**From:**  
**Sent:** 13 September 2023 14:19  
**To:** DCAdmin  
**Subject:** Emley development comments/ objections to note

2023/92255 Land at Green Acres Close, Emley, Variation of Conditions 1 (Plans) , 2 (Crime Prevention) and 15 (Permitted Development) of Previous reserved matters approval 2021/93286 pursuant to outline permission 2020/91215 And

2023/92327 Land at Green Acres Close – modified plans for 6 Dwellings plus parking and landscaping and modified plans for ball stop netting.

Drawing Title	Ball Strike Net		
Site	Wentworth Drive, Emley		
Scale	1:100/1:200 @A2	Date	27/06/23
Drawn	MC		
Drawing No.	2155.110	Rev.	-
Thorpe Arch Grange Walton Road Thorp Arch LS23 7BA 01937 543599 www.newethomes.co.uk

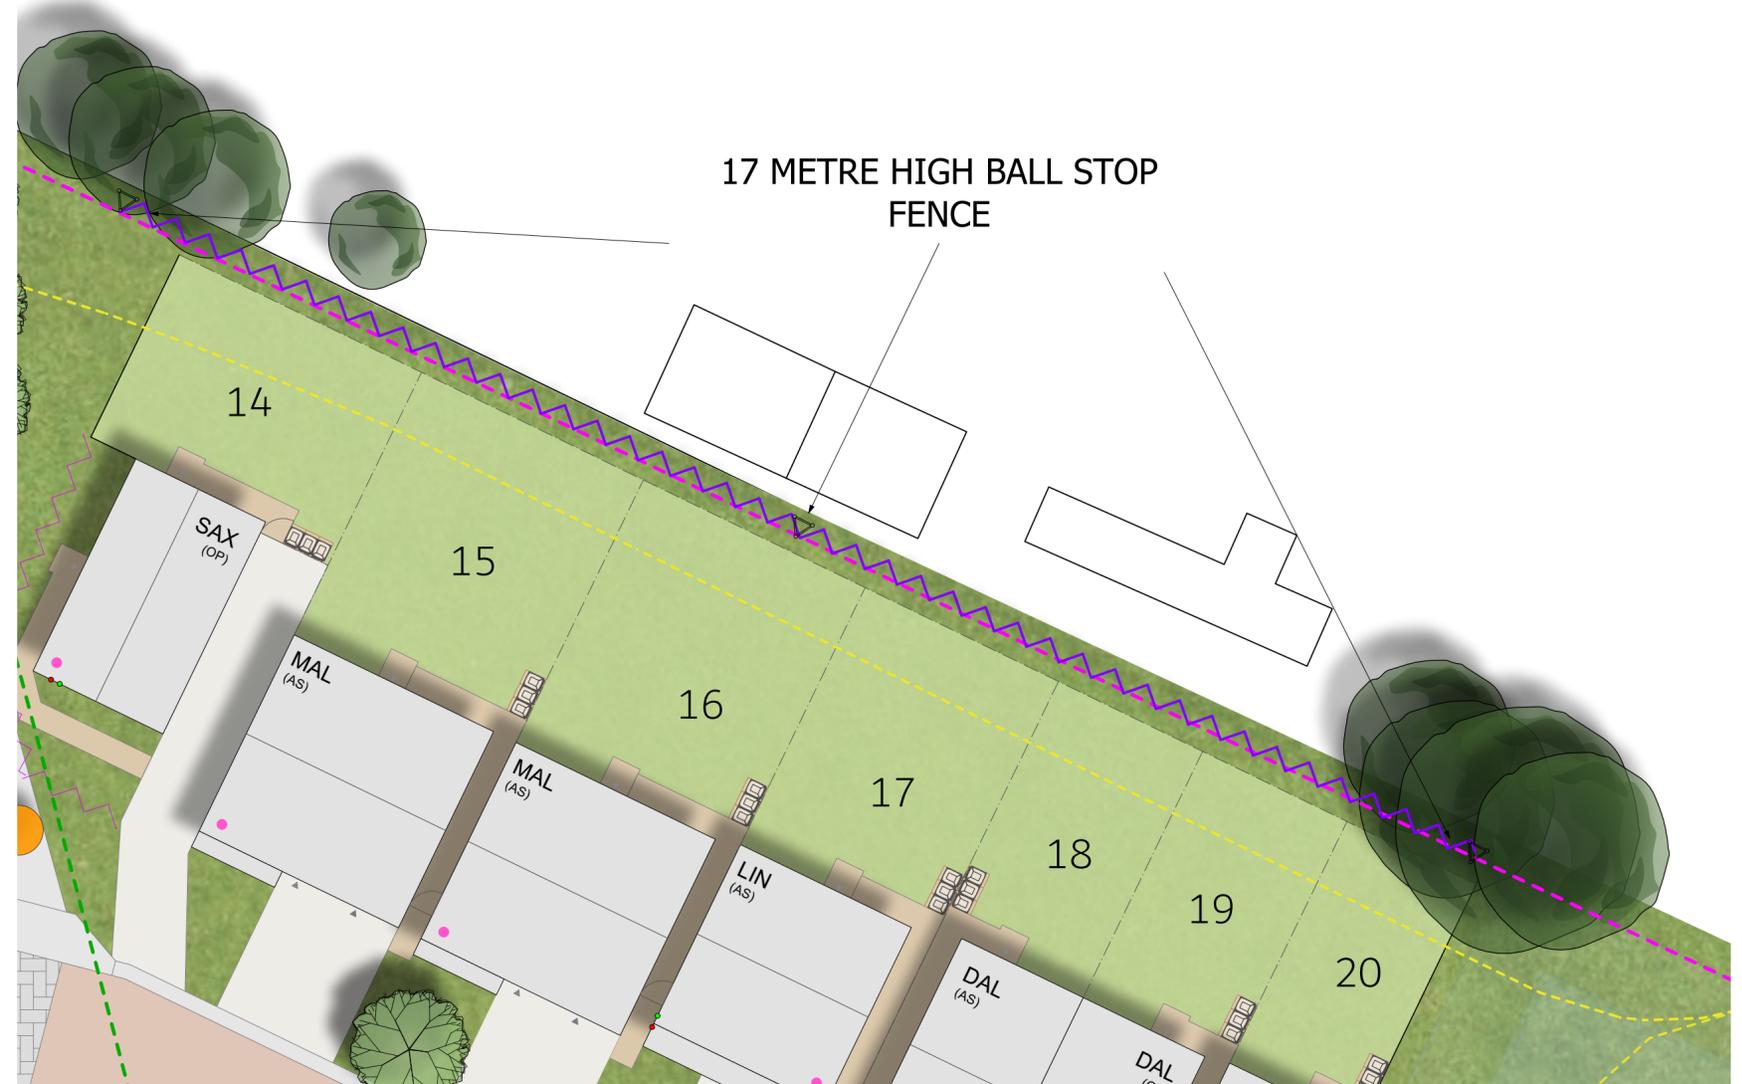
8 – The submitted ‘Cricket Pitch Section’ plan and the ‘Ball Strike Net Plan’ both dated 27/06/23 prepared by Newett Homes is not sufficient. There is no information or evidence to show that the stanchions/supports and netting design nor the new position of the net, nor the height of the net is adequate. The cricket field and the development land are exposed to high winds and adverse weather and this needs to be factored into any design. The balls strike netting needs to be robust enough to withstand the extremes of weather experienced in Emley, and to prevent rattling and whistling noises disturbing residents in the vicinity.

10 - The proposed netting and its height is not what was approved in the Planning Application 2021/93286. The Labosport LSUK.21-0698 dated 19/11/2021 gave a height of 18 metres but Newett are now using 17 meters. A new Labosport/Newett Boundary Risk A new assessment is required to look at the heights again particularly due to the proposed nets being moved and the claimed PROW now being incorporated into the new design. As already stated this should be a physical survey by Labosport not a desk top survey, they need to visit the site to appreciate the position and the situation.

11 - The proposed netting is not only lower than it should be but it does not extend to the perimeters originally proposed. It is shown as not extending the full length of the cricket field wall, ie where the proposed attenuation tanks are to be grassed over and the development children play this area is not covered by the safety of the nets. Are children not as important as the houses. This is of course in addition to the fact that there will need be access for a

“cherry picker” machine space for repair / maintenance of the ball stop netting - which would need a clear 3.00 m drive way, and this is not reflected in the most recent proposals to Kirklees.
